A57 Link Roads

8.3 STATEMENT OF COMMON GROUND WITH HIGH PEAK BOROUGH COUNCIL

Regulation Number:	Regulation 5(2)(c)
Planning Inspectorate Scheme Reference	TR010034
Application Document Reference	TR010034/APP/8.3
Author:	A57 Link Roads Project Team, National Highways and Atkins

- LEGEND**
- MODELLED QUALIFYING FEATURES AND PUBLIC ACCESS
  - DEFRA PCM LINKS COINCIDING WITH ROADS MEETING THE DMRB LA105 TRAFFIC SCREENING CRITERIA
  - ROADS MEETING DMRB LA105 TRAFFIC SCREENING CRITERIA

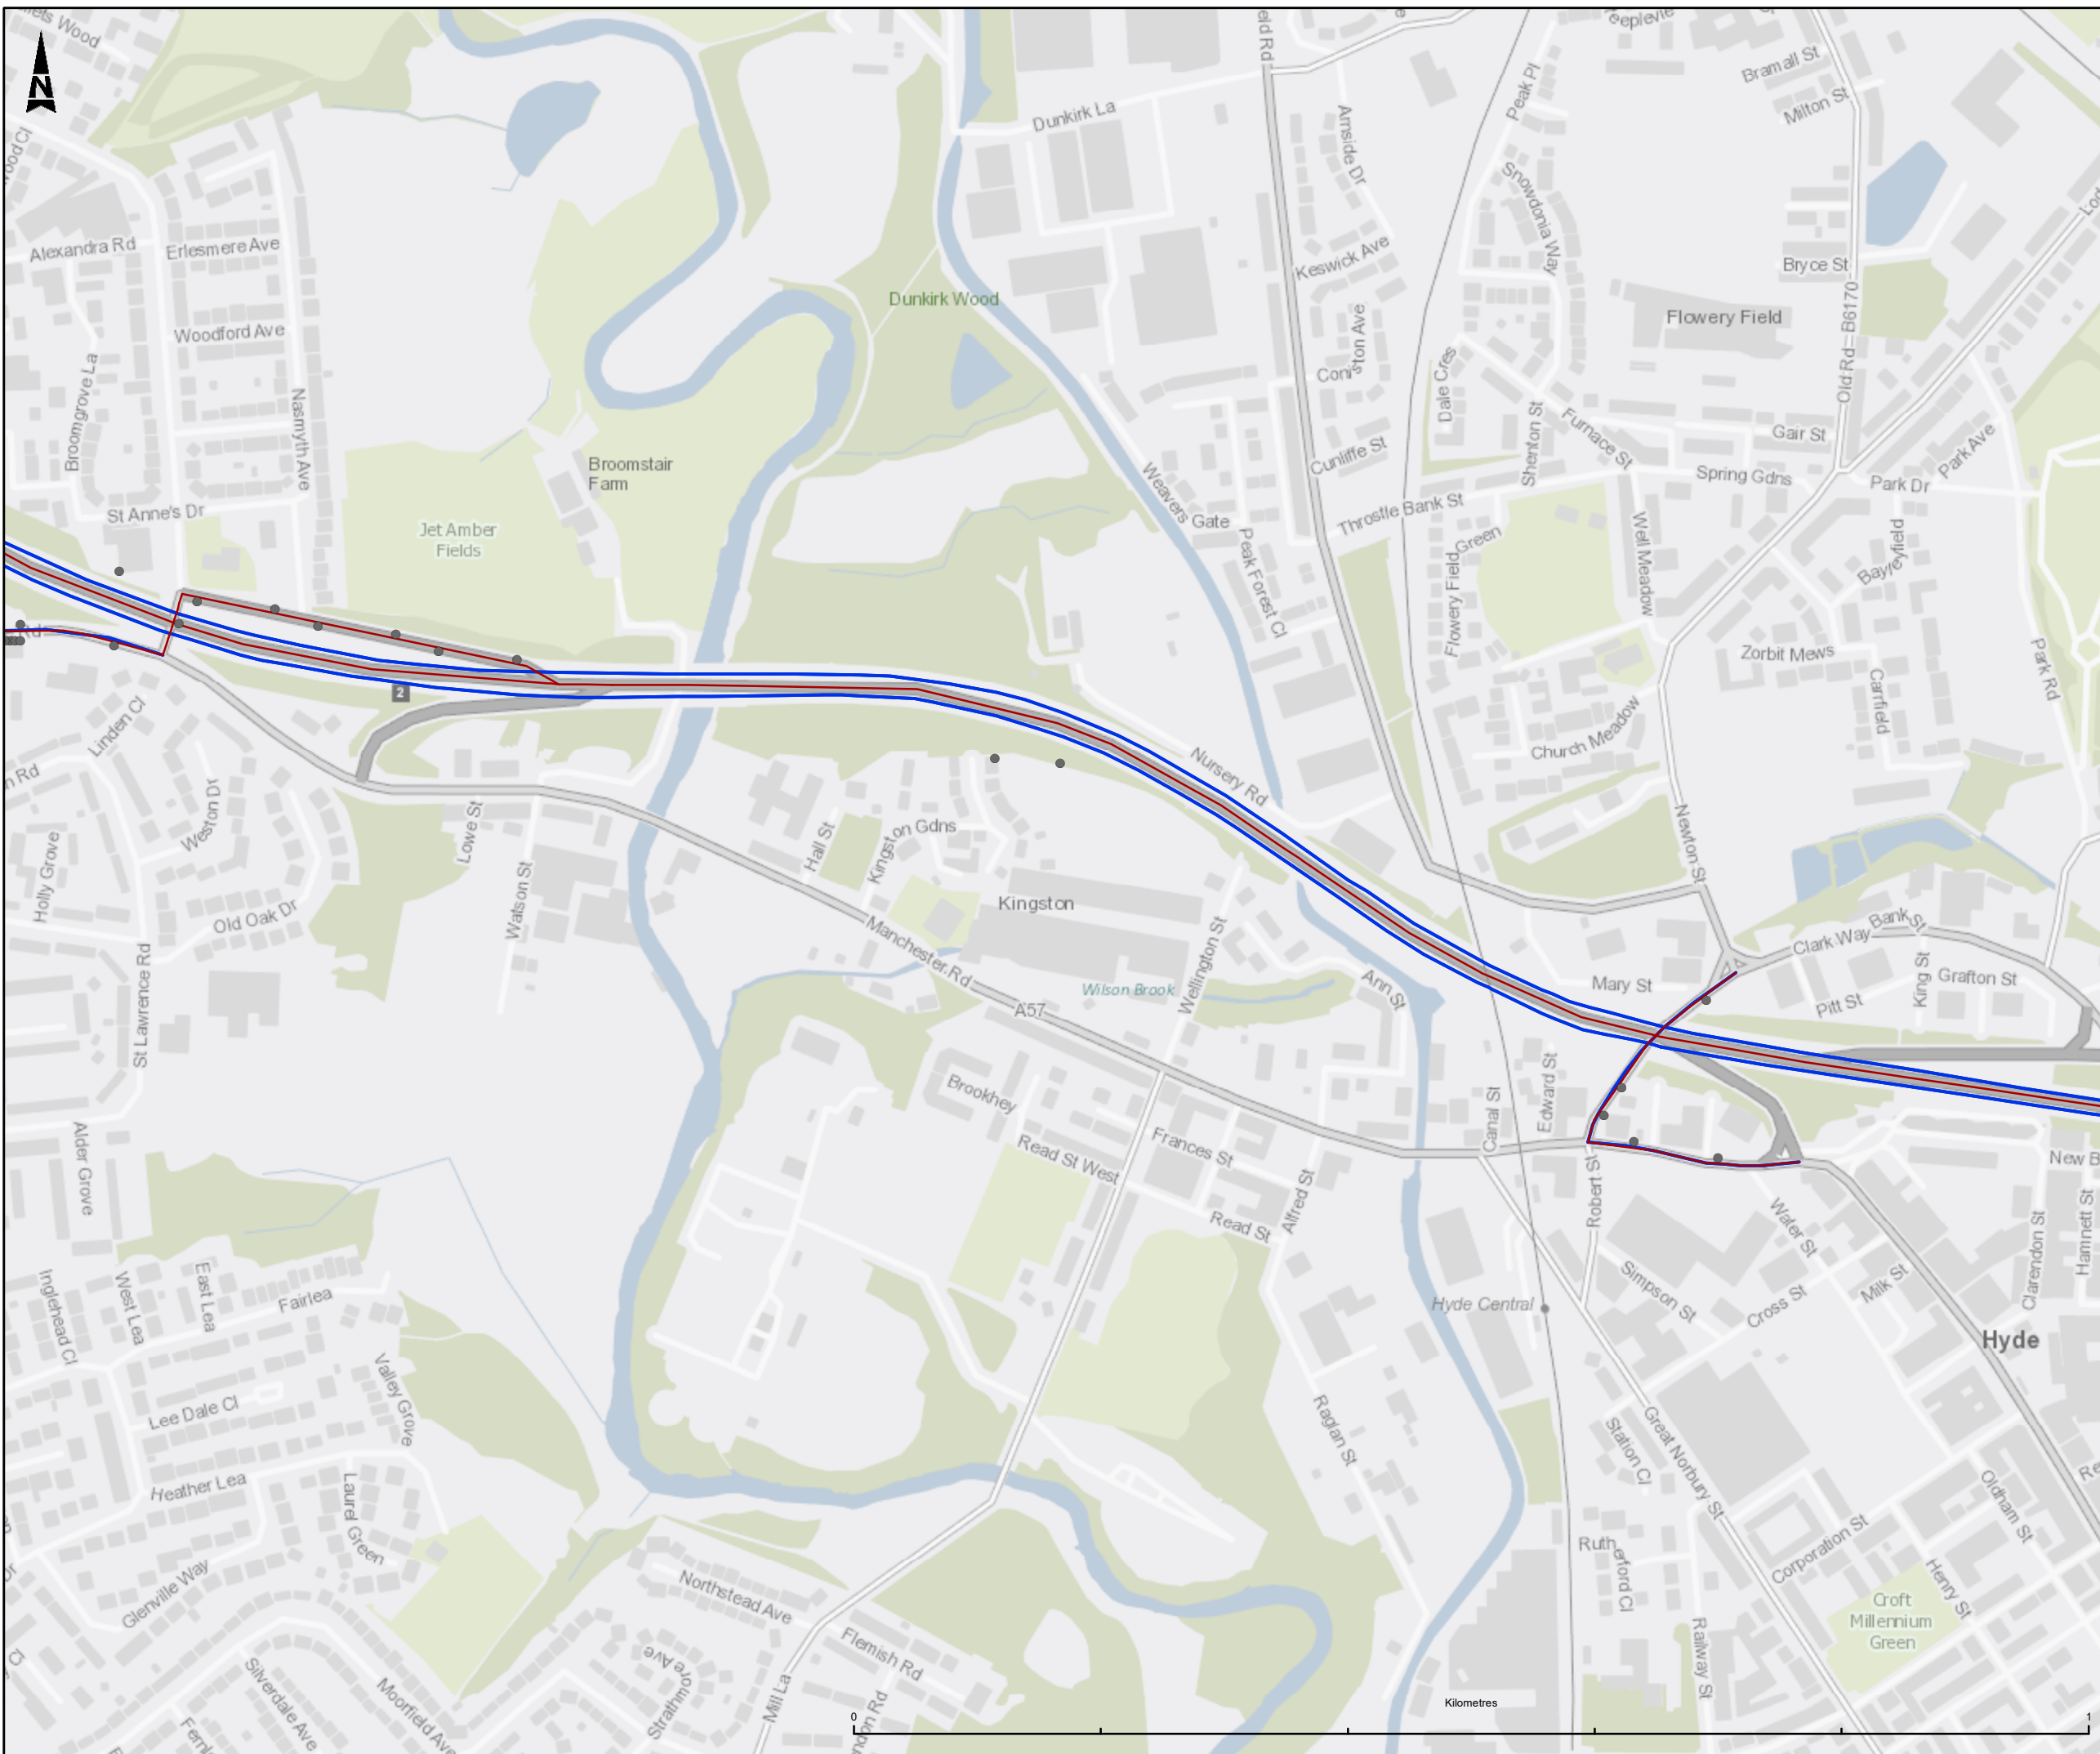
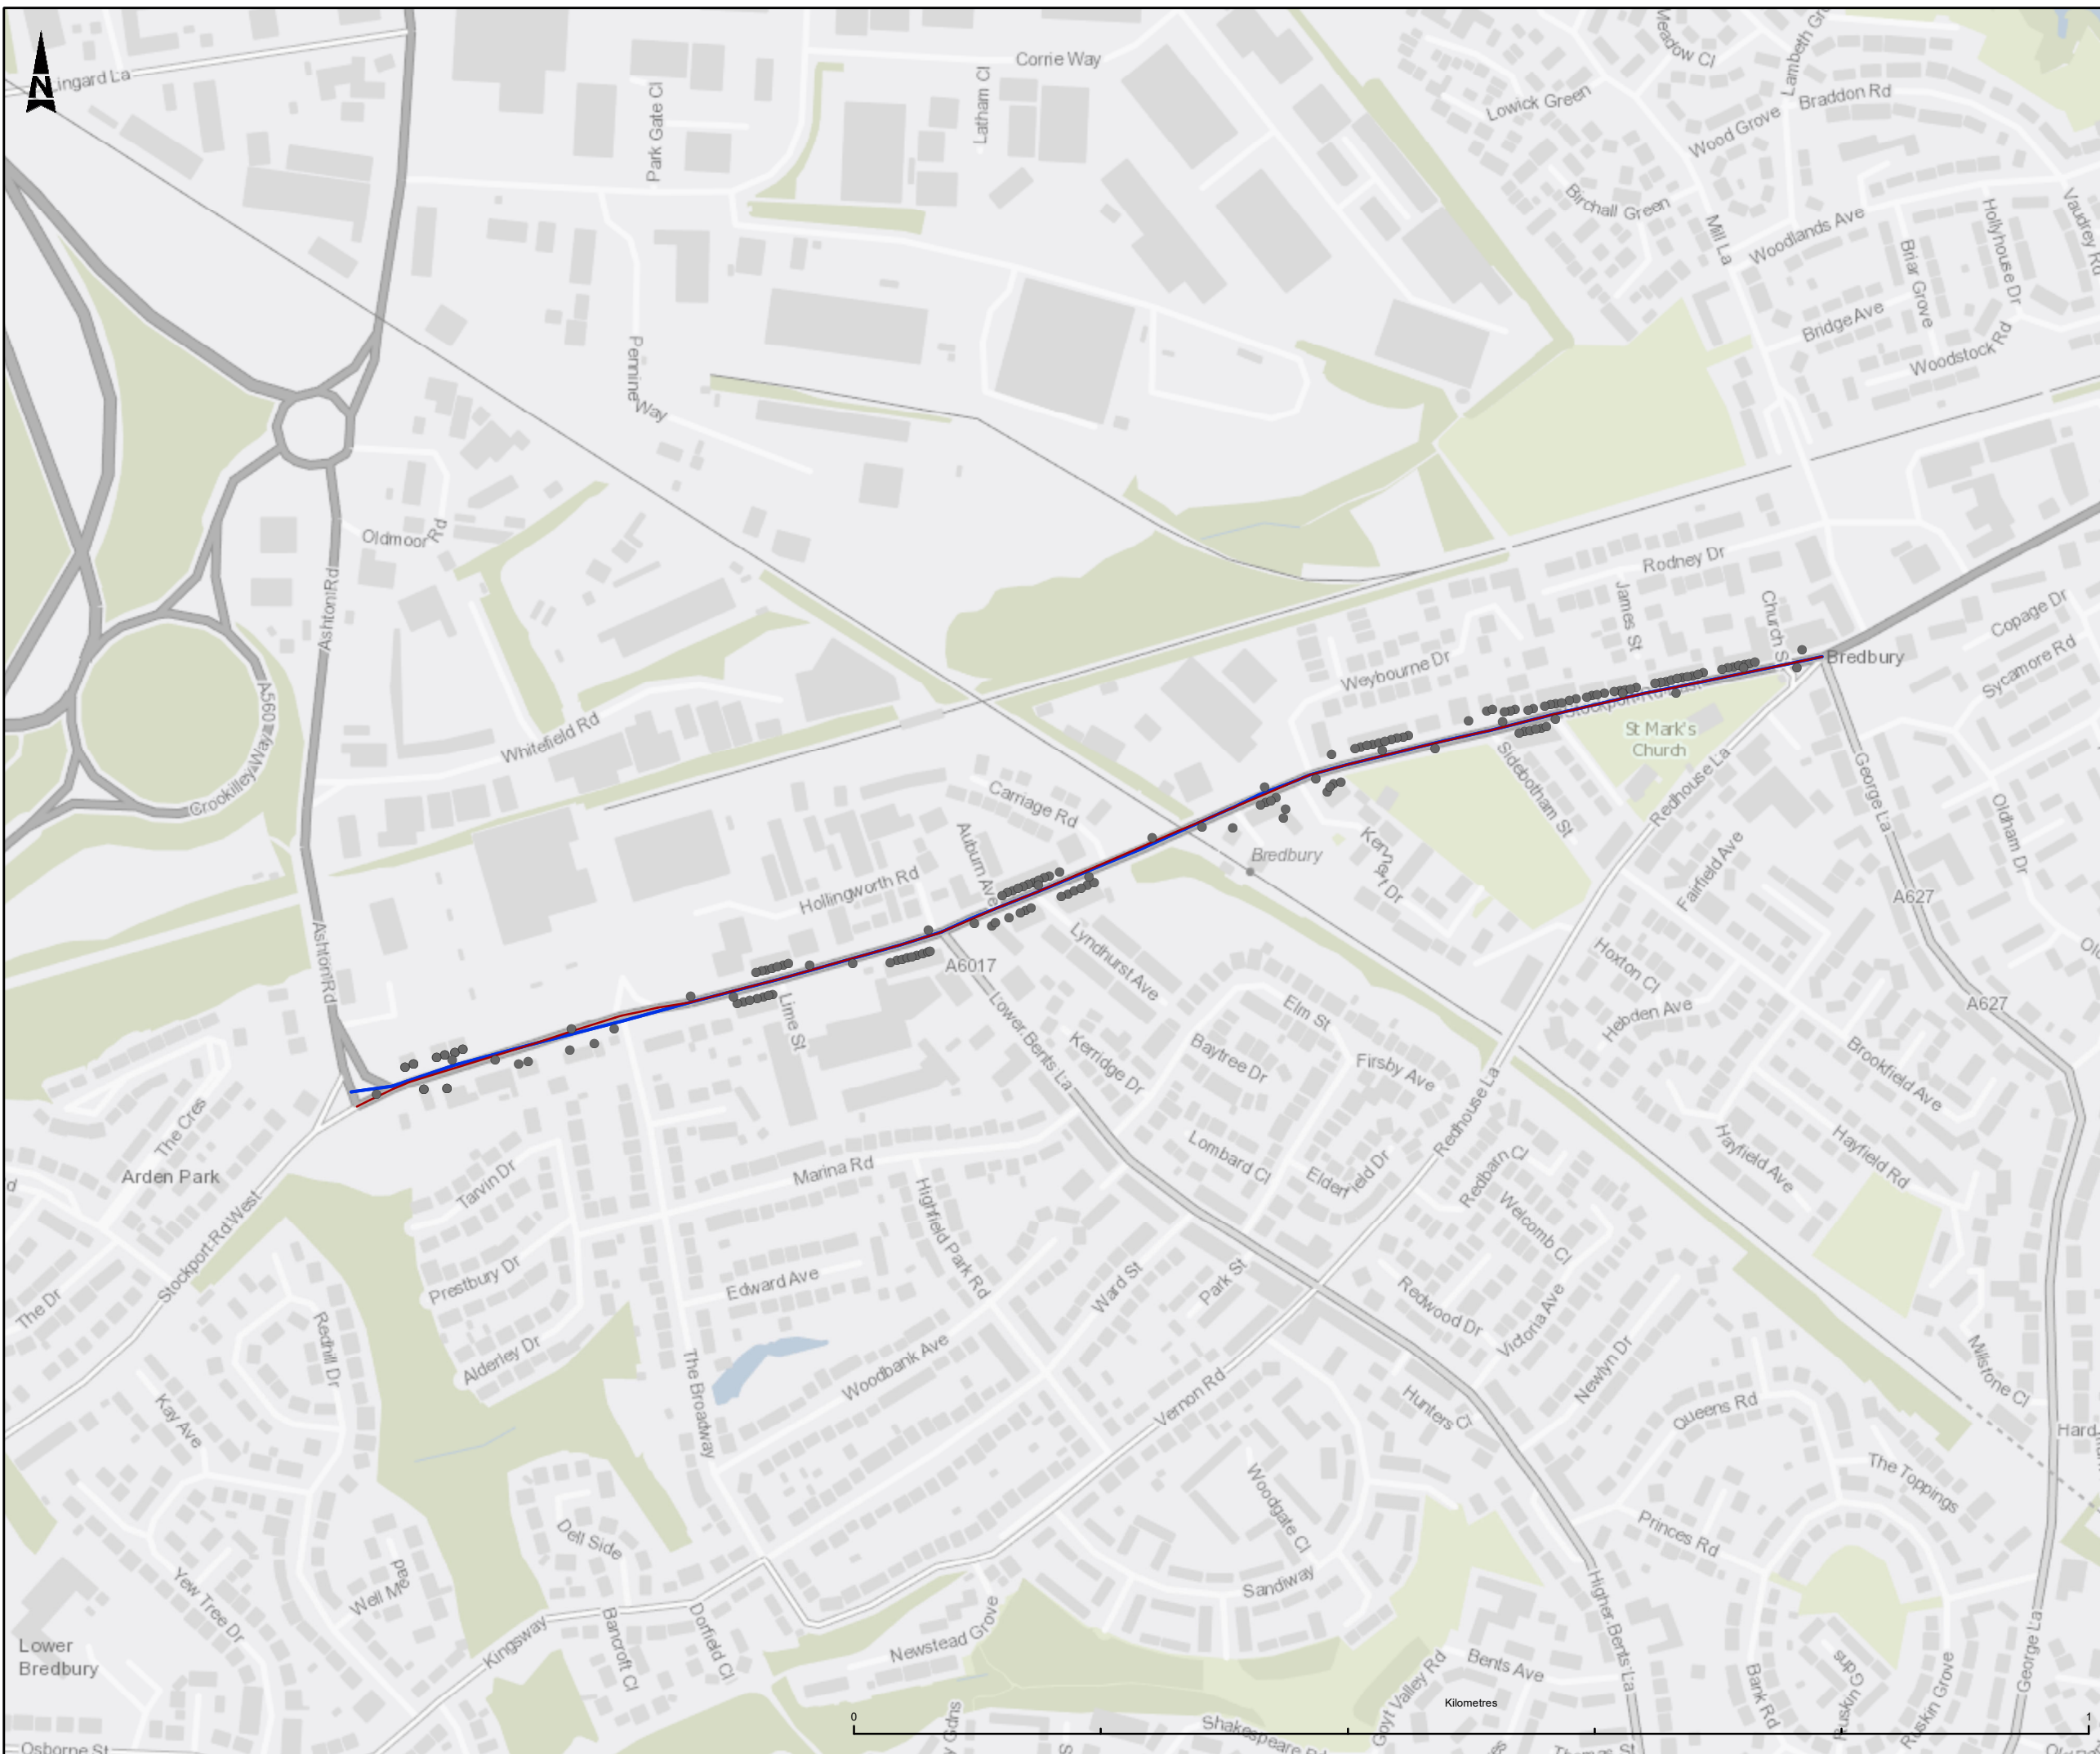
3.2	Environmental Statement (ES) [APP-061]	Air Quality Methodology Dinting Vale	The Consultee questioned the air quality results at Dinting Vale.	The air quality assessment has been undertaken in accordance with DMRB LA105 with the air quality study area determined on the basis of traffic change criteria given this guidance. A detailed assessment of air quality has been undertaken for all areas where traffic changes are expected, which includes the Dinting Vale area. Full results will be reported in the Environmental Statement [APP-061].	Agreed
